**RE: Full Gospel Tabernacle Church
Draper Aden Associates Project No.18080144-01**

Please see the provided comment responses in **bold** to your comments on the utility layout for Full Gospel Tabernacle Church.

EXISTING CONDITIONS PLAN
FULL GOSPEL TABERNACLE CHURCH
 COATS, NC

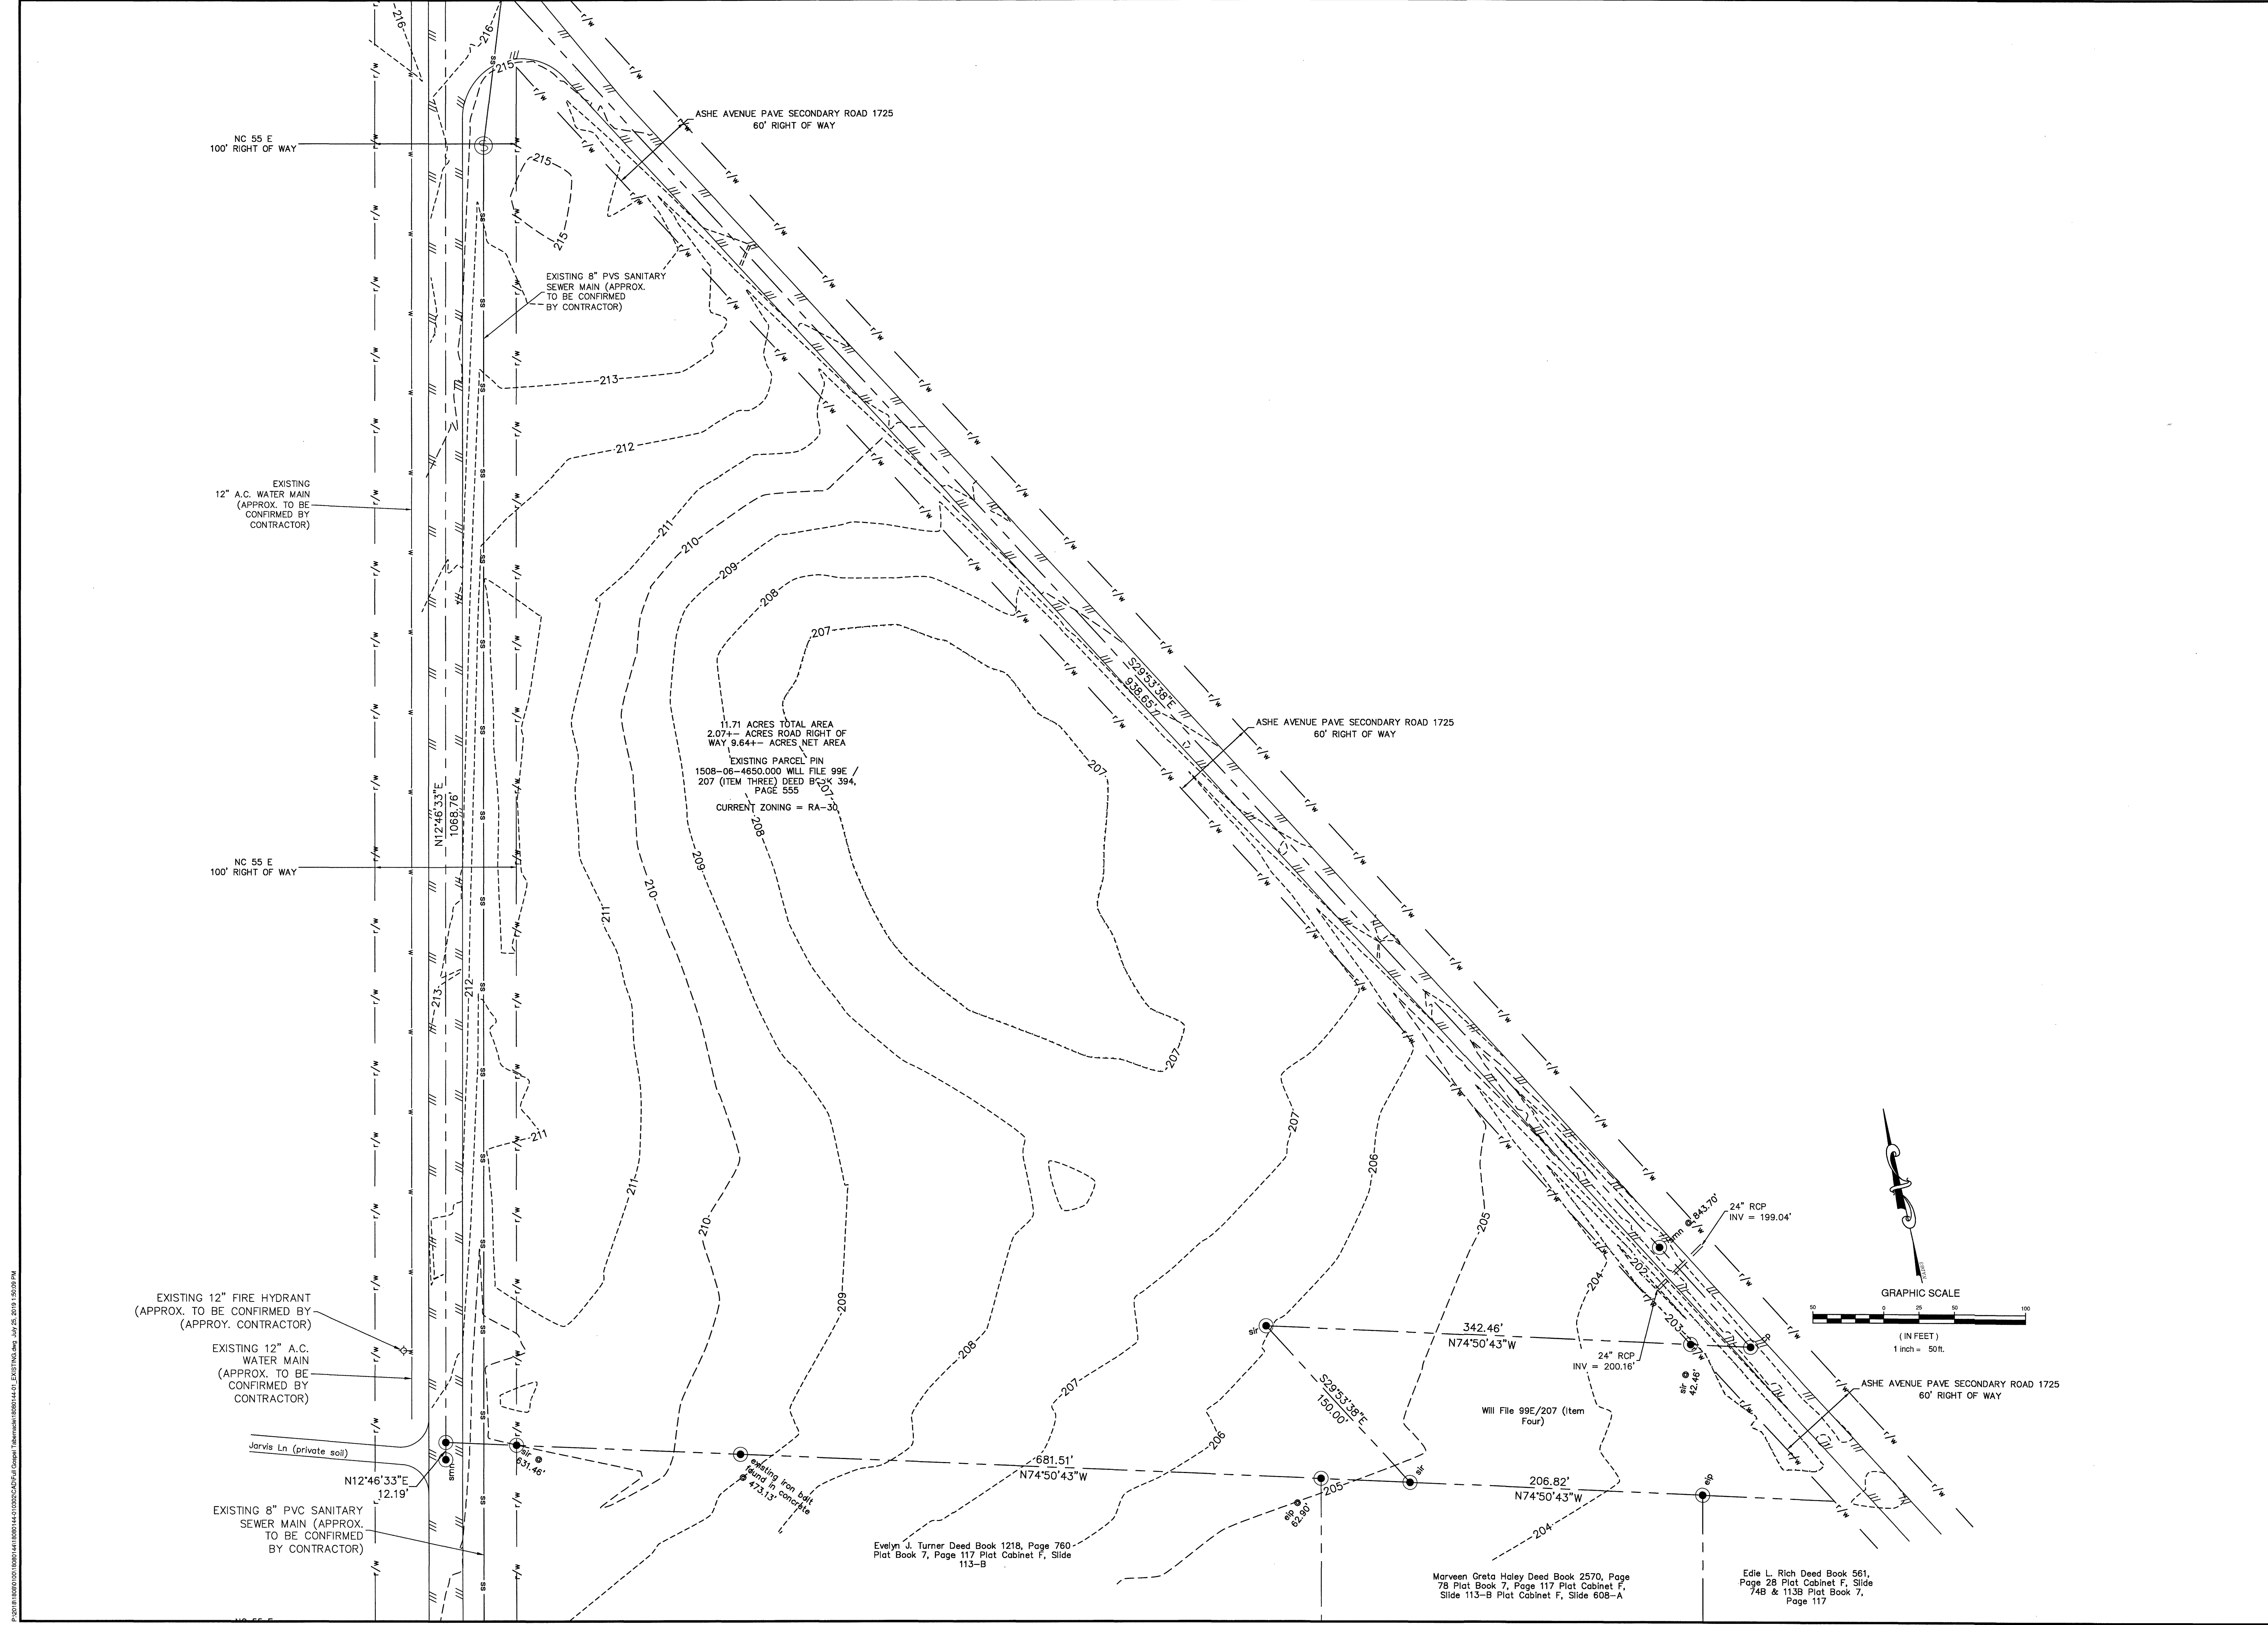
2. The existing 12-inch water main should be noted as AC.
2. Updated multileader to read "12-inch AC water line". See C3.0 & C5.0.
3. The existing sewer main should be noted as PVC.

SITE LAYOUT & UTILITY PLAN
FULL GOSPEL TABERNACLE CHURCH
 COATS, NC

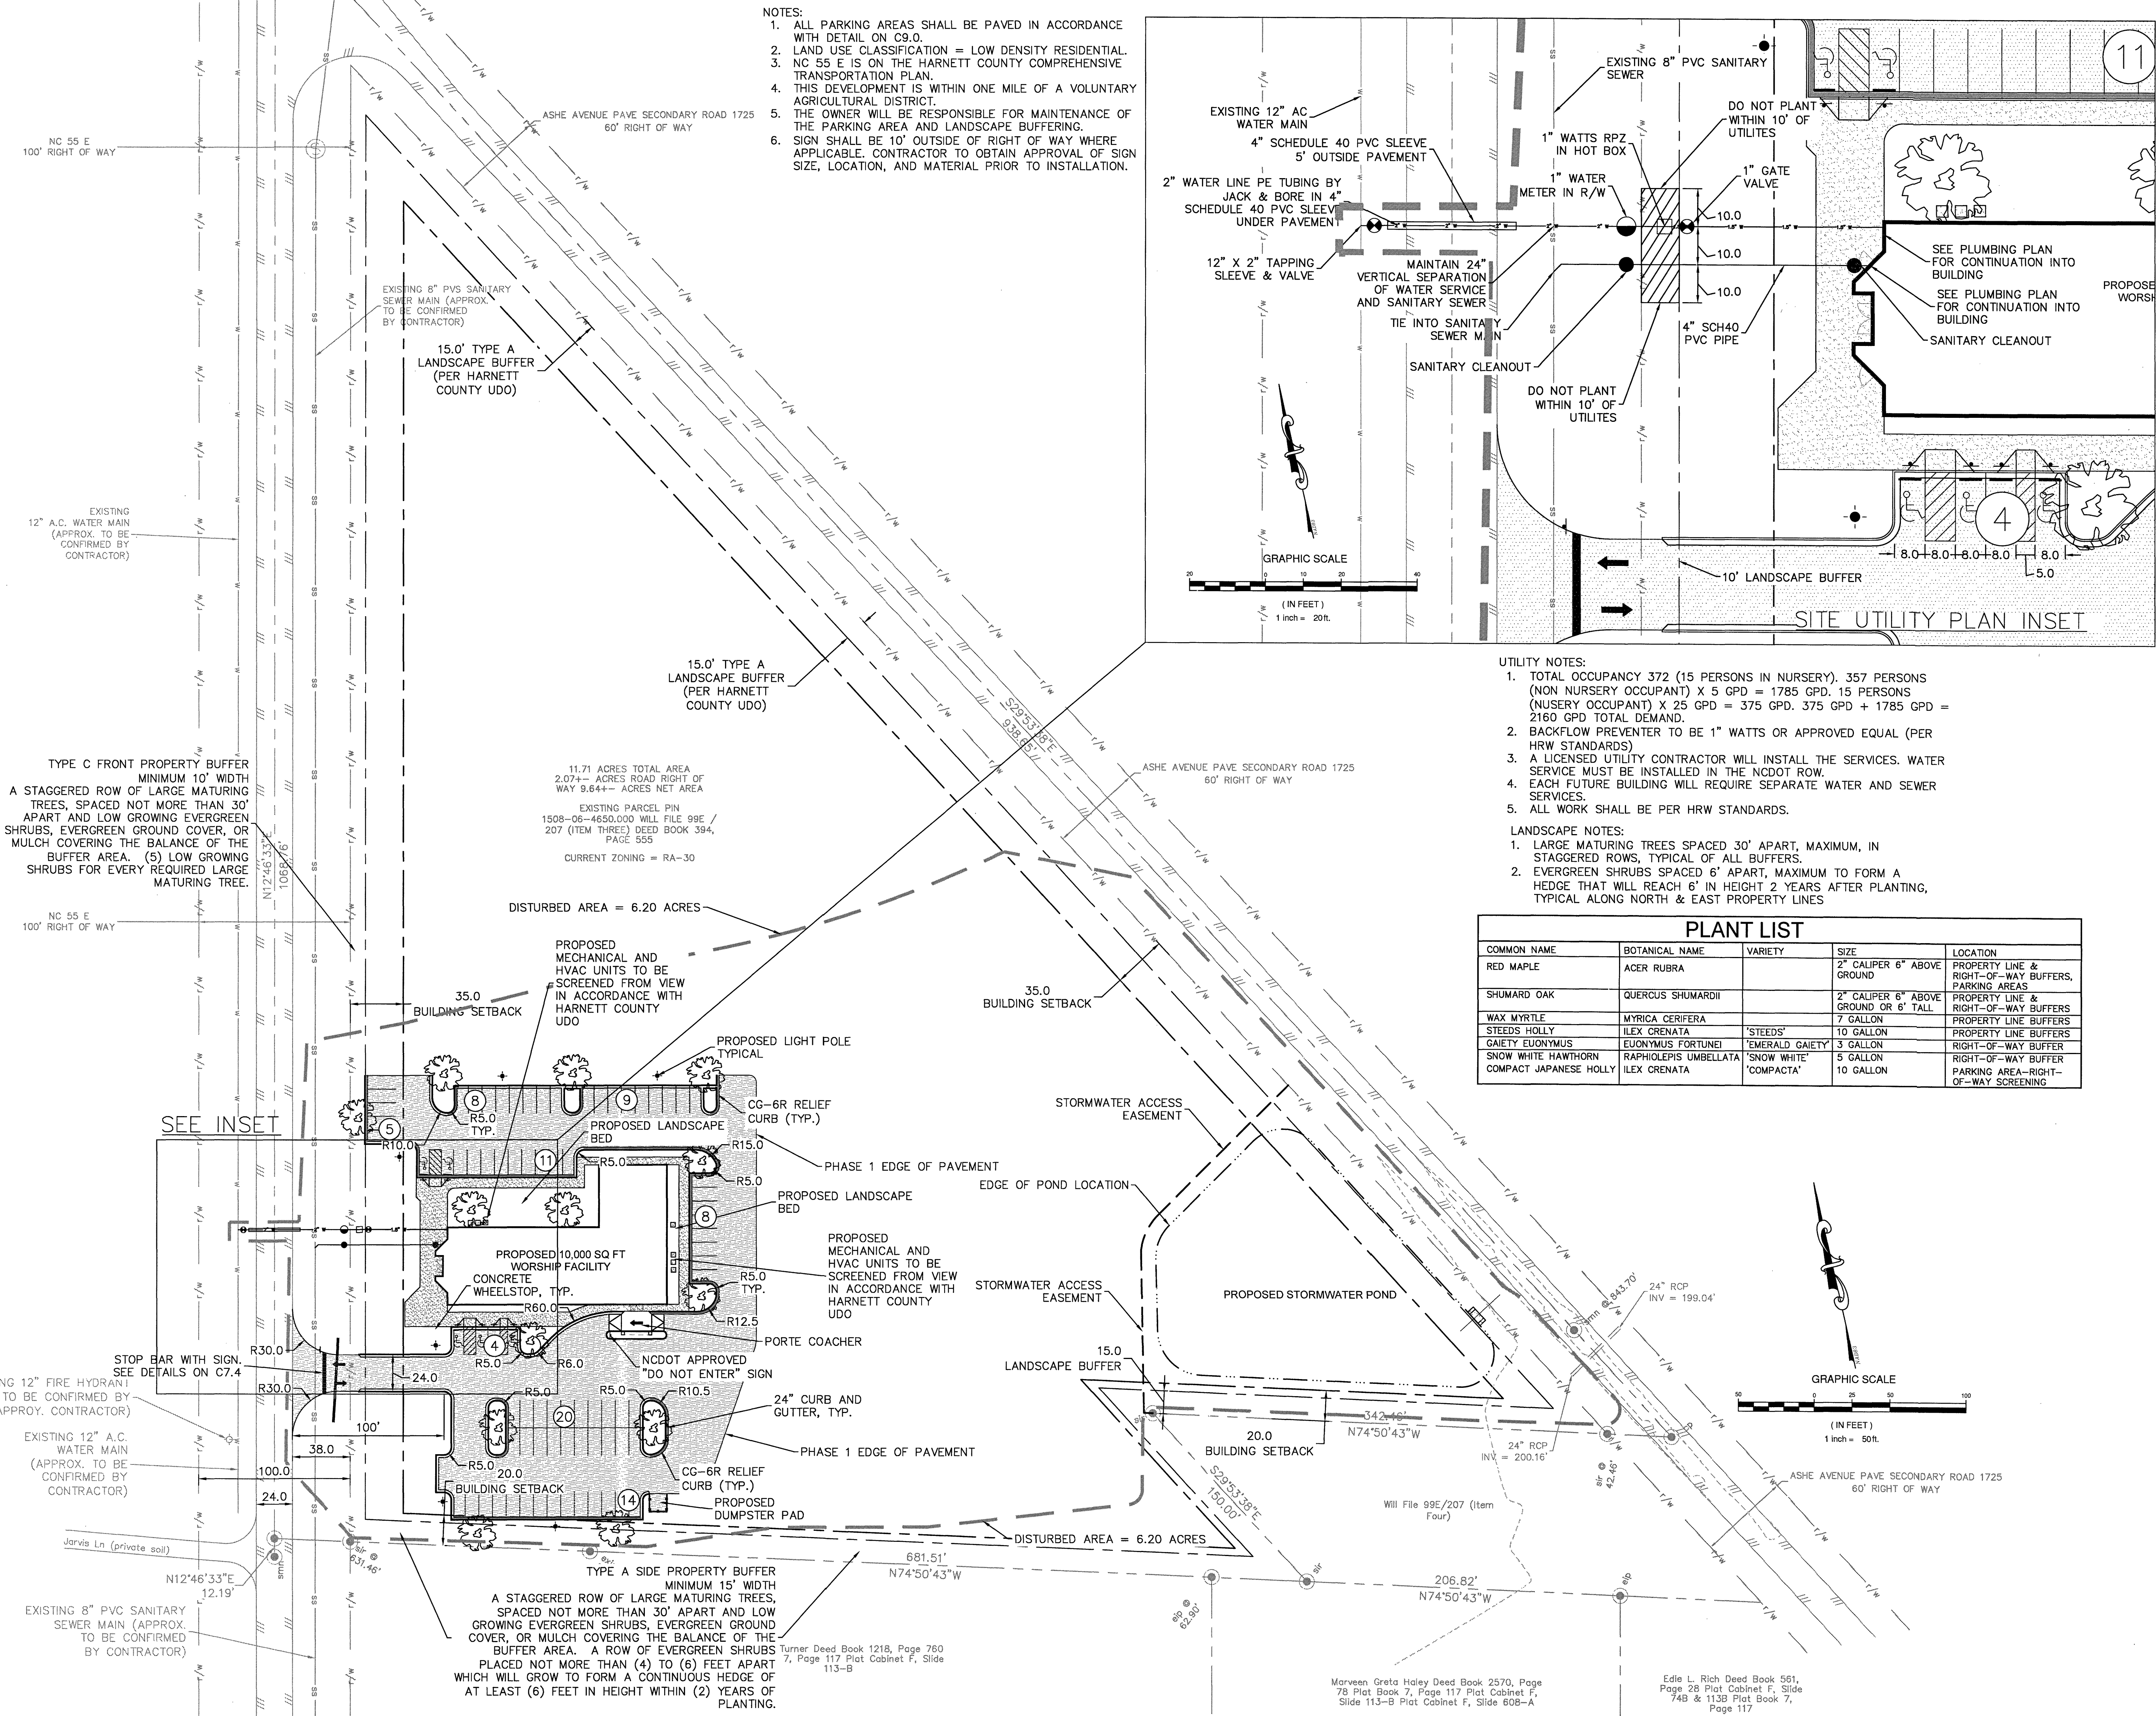
1. The proposed connection to the existing 12-inch main will require a tapping sleeve and valve on any service tap 2-inch and larger.
1. Tap updated to read "12-inch tapping sleeve with 2-inch gate valve". See sheet C5.0.

3. Updated multileader to call out PVC sewer main. See C3.0 & C5.0.
4. Will there be any food preparation in the proposed building? Please include a grease trap in accordance with the Sewer Use Ordinance as applicable.

4. No food preparation is included as part of this work.
5. The water meter must be installed within the NCDOT R/W.
5. Water meter moved further inside NCDOT R/W for clarification. Multileader updated to read, "1" WATER METER IN R/W". See C5.0.

6. Note the separation between the gravity sewer and proposed 2-inch service line.
6. Note added, "MAINTAIN 24" VERTICAL SEPARATION OF WATER SERVICE AND SANITARY SEWER". See C5.0.

7. Note the method of installation for service line across Hwy 55. Conduit/sleeve is preferred for large services under highways.

7. **4" schedule 40 PVC sleeve to be used to install water service. See C5.0.**
8. Why is the water service tubing reducing before the 1-inch meter? HRW uses ¾-inch, 1-inch, and 2-inch service lines. If the water meter is 1-inch why is the service lines different sizes than 1-inch?
8. **Water service updated to 1" into RPZ Hot Box. 1.5" service line is outside of NCDOT R/W and is there to assist with pressure losses. See C5.0.**
9. Is the proposed usages just for the 10,000Sq Ft Building? The Plan review documentation notes 281 seats @ 843gpd. Please confirm these usages because they do not correspond with the usages on the plans.
9. **The 281 seats listed on the corner is for the main assembly area only. The usage on sheet C5.0 of 2160 GPD is for max occupancy of the building.**
10. Include NCDOT Encroachment Agreement.
10. **NCDOT Encroachment Agreement included.**
